Our ref: DOC22/361587

Your ref: SSD-17424905

Subject: EHG comments on Response to Submissions for the Pymble Ladies College – Grey House Precinct - SSD-17424905

Subject: EHG comments on the Response to Submissions for Pymble Ladies College – Grey House Precinct - SSD-17424905

Figure 2.1 Native vegetation cover within 1500m buffer around the site. Seedmap, 2021.

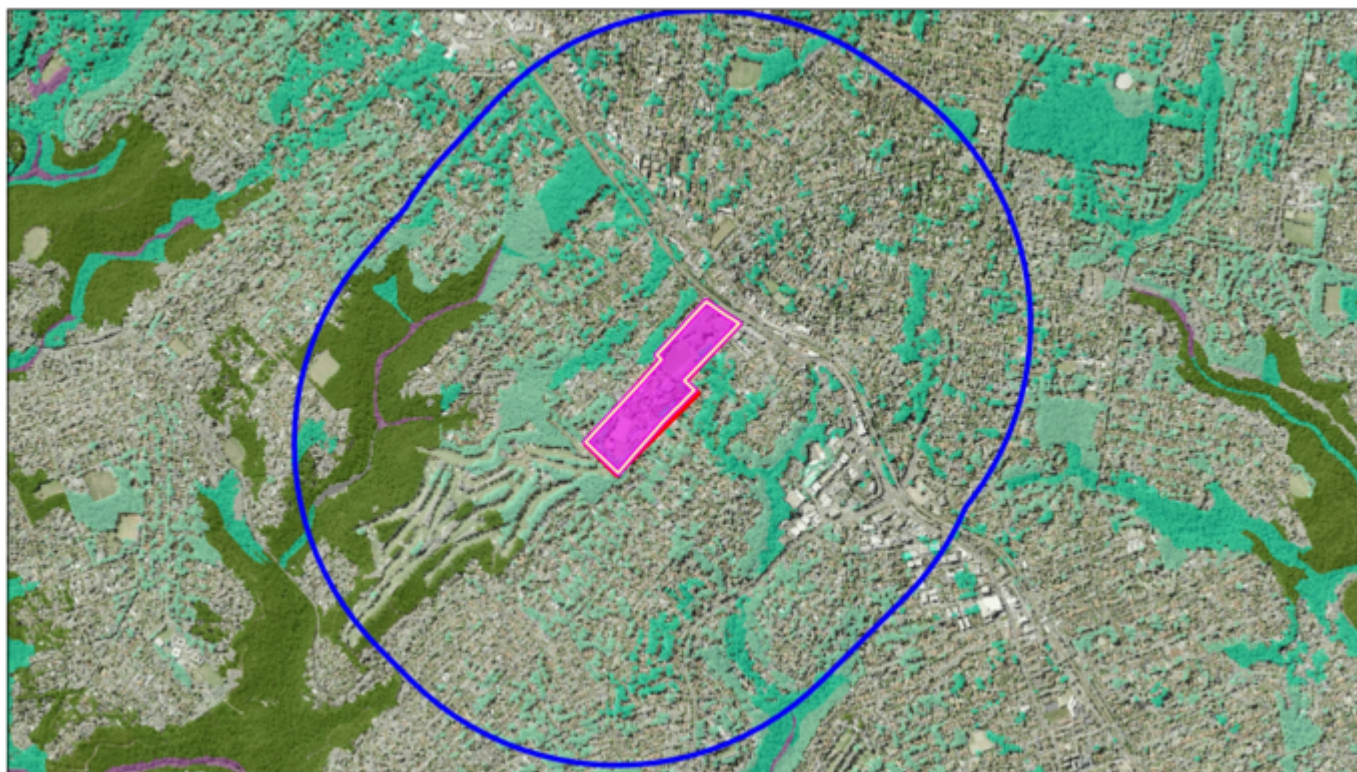
- It is not clear from Figure 2.1 what native vegetation has been included in the count of 25% cover as there’s no legend to the map. RtS needs to clarify if both dark green and aqua vegetation been included and why has a map been provided with the vegetation marked as different colours.

Figure 5.1. Vegetation zones and BAM plot locations on site. Six Maps, 2021.

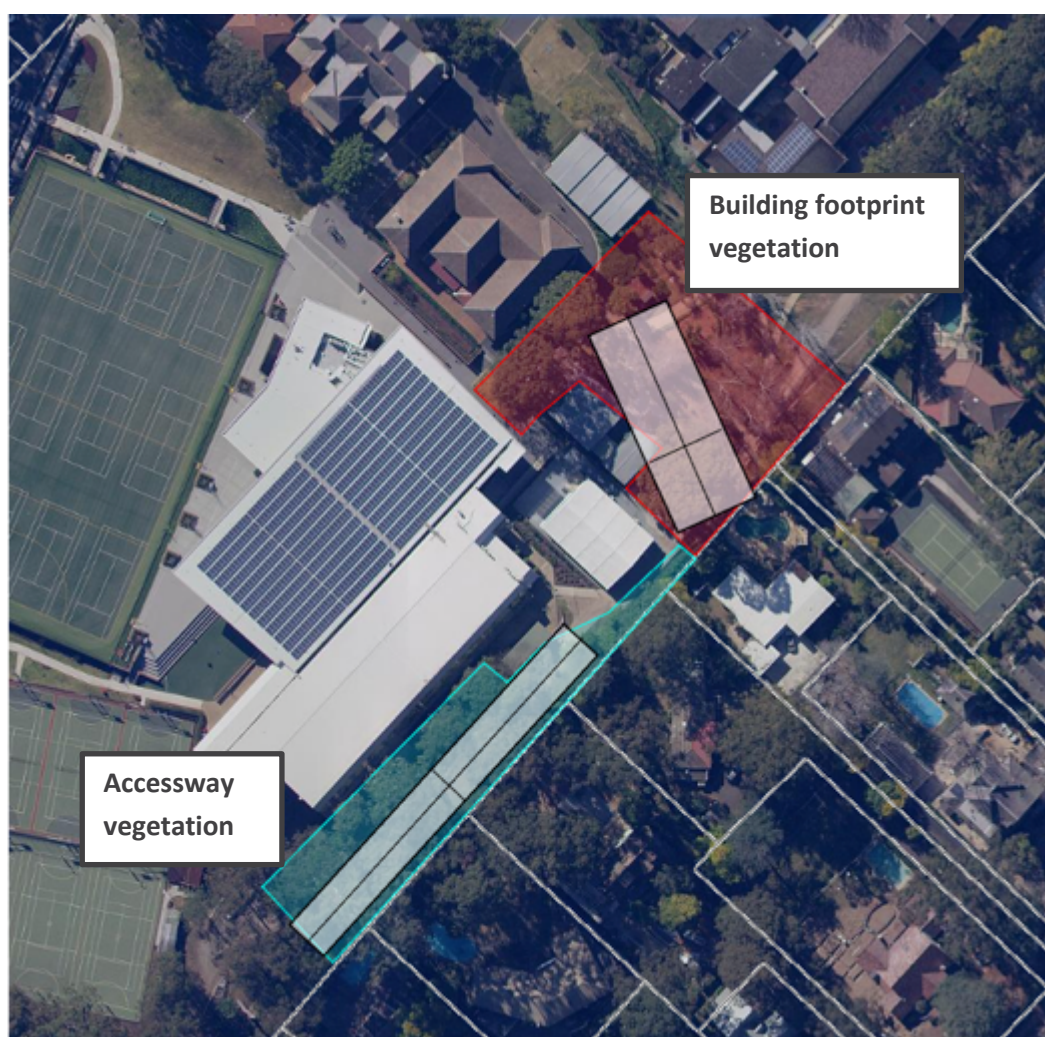
- The map showing vegetation zones should be provided with other information on the native vegetation present (i.e., in section 3 of the report) rather than in the impact section.

Figure 5.3 Impact Area in Native Vegetation in Zone 2 Accessway.

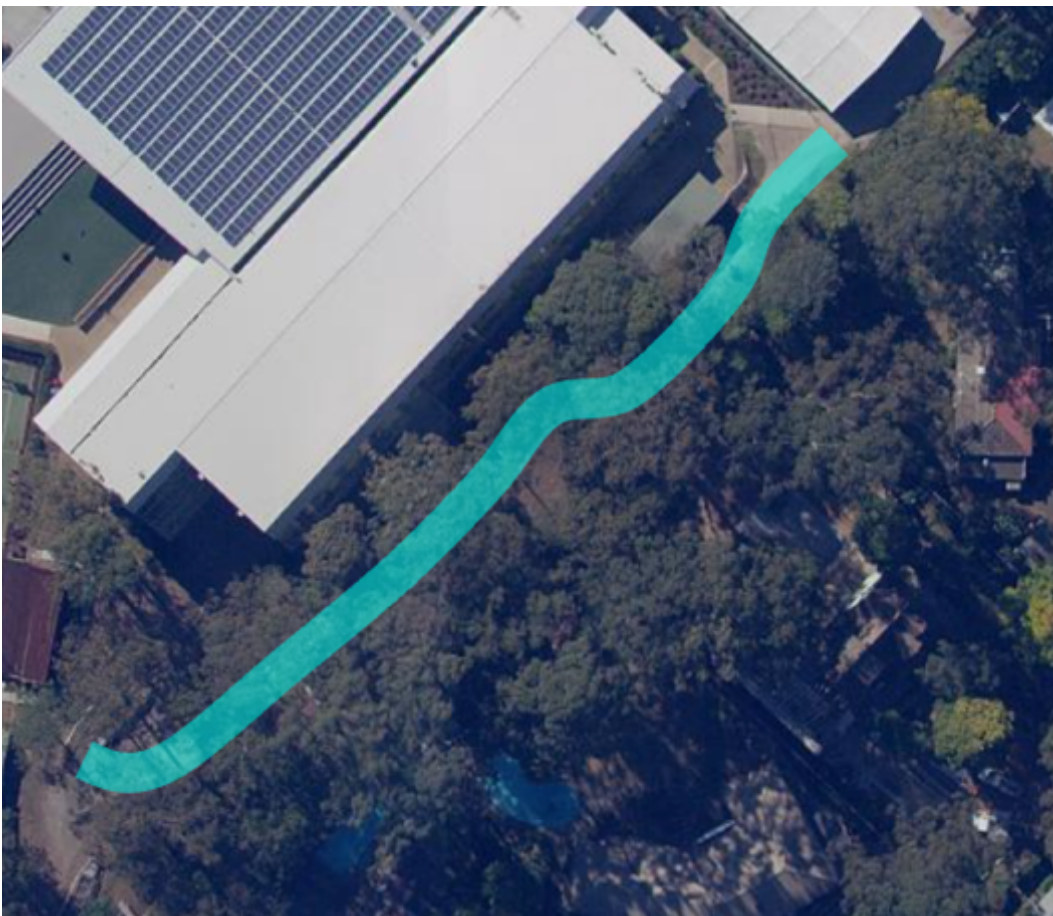
- Four trees will be removed for the accessway. The impacts have been calculated at a loss of 5% canopy cover. No justification is provided for the figure of 5%. EES considers this impact value is likely insufficient given the loss of four trees and the trimming that is required.
